Planning Application Ref: AW/231/18/T

Location: Flat 3 – Mariners, 56 Aldwick Avenue, Aldwick PO21 3FJ

Description of works: 2m Crown Reduction to 1No. Oak , 3No. Maple and 1No. Red Maple trees. 1.5m Crown Reduction to 2No. Silver Birch

- 11) Oak tree
- 12) Maple trees X 3 + Silver Birch
- 13) Copper Maple,
- 14) Conifer Hedge.
- 14) Silver Birch

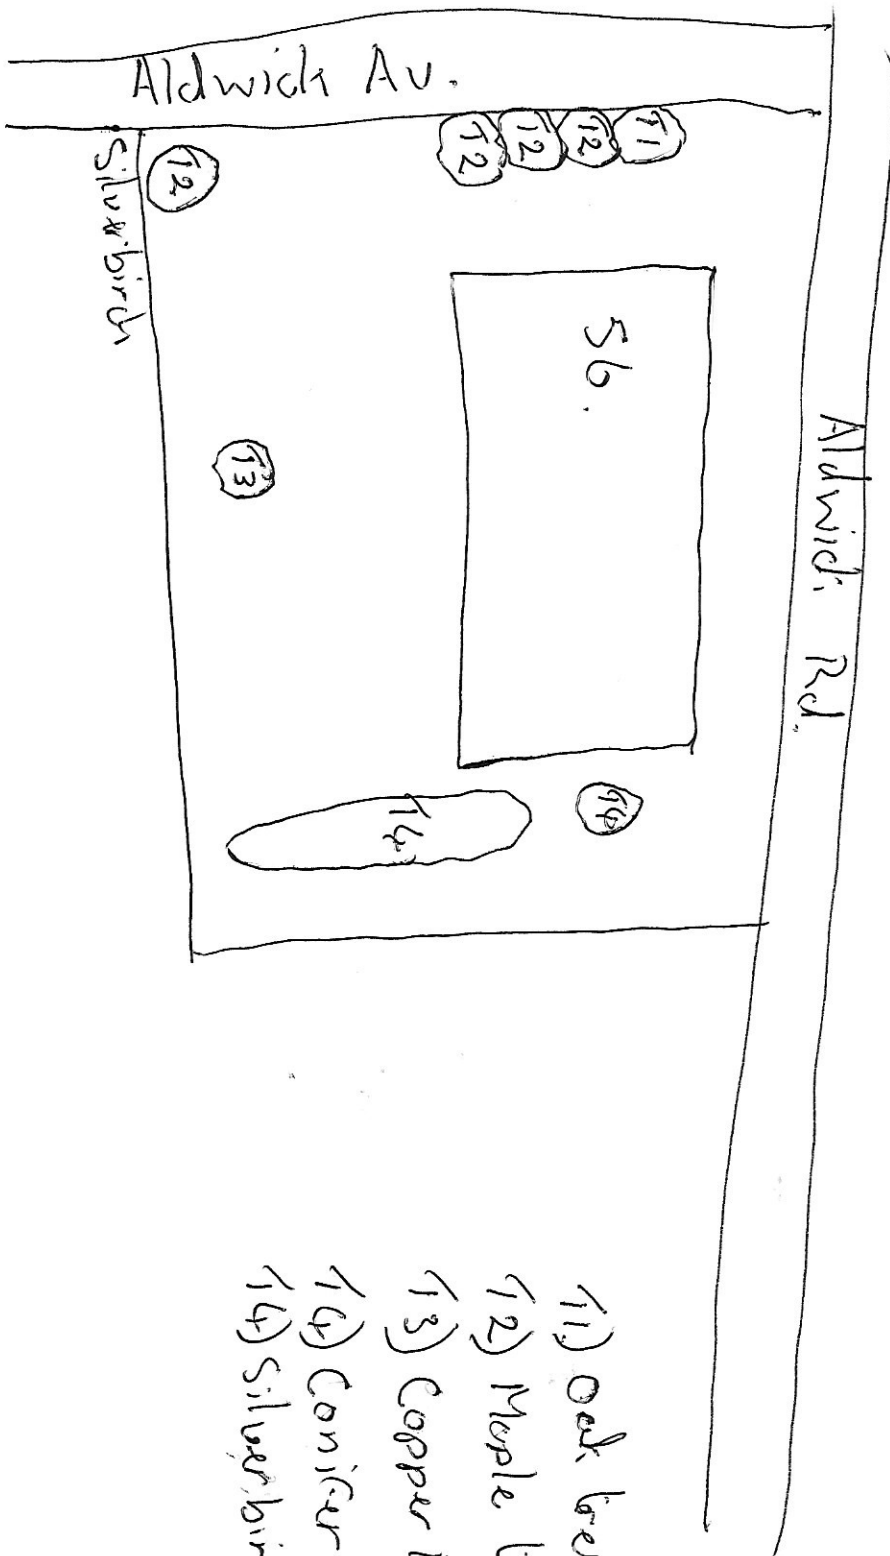
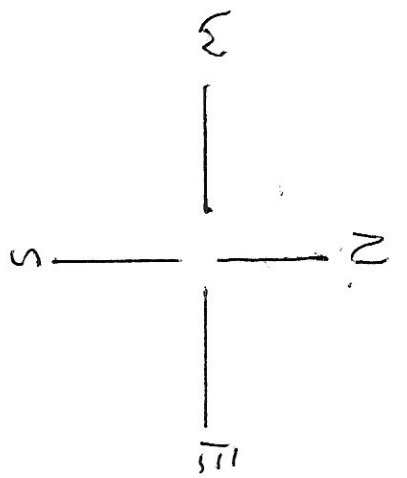
- These trees appear to be outwardly healthy (silver birch T2 being an exception) and have undergone past crown reduction. Only the oak and one maple (T3) on the southern boundary could be considered of high value at this time.
- The majority grow alongside the plot perimeter and can be seen from neighbouring dwellings and public highway.

- The removal of crown material which has developed since the last operation must be done sympathetically and with respect to established 'knuckles' so as not to extend beyond the point of origin.
- The long-term vitality of these trees is best respected when significant pruning work such as proposed, is undertaken during either the mid-summer (mid-June to mid-September) or mid-winter (mid-December to mid-February) periods. The work proposed must only be undertaken during these periods.
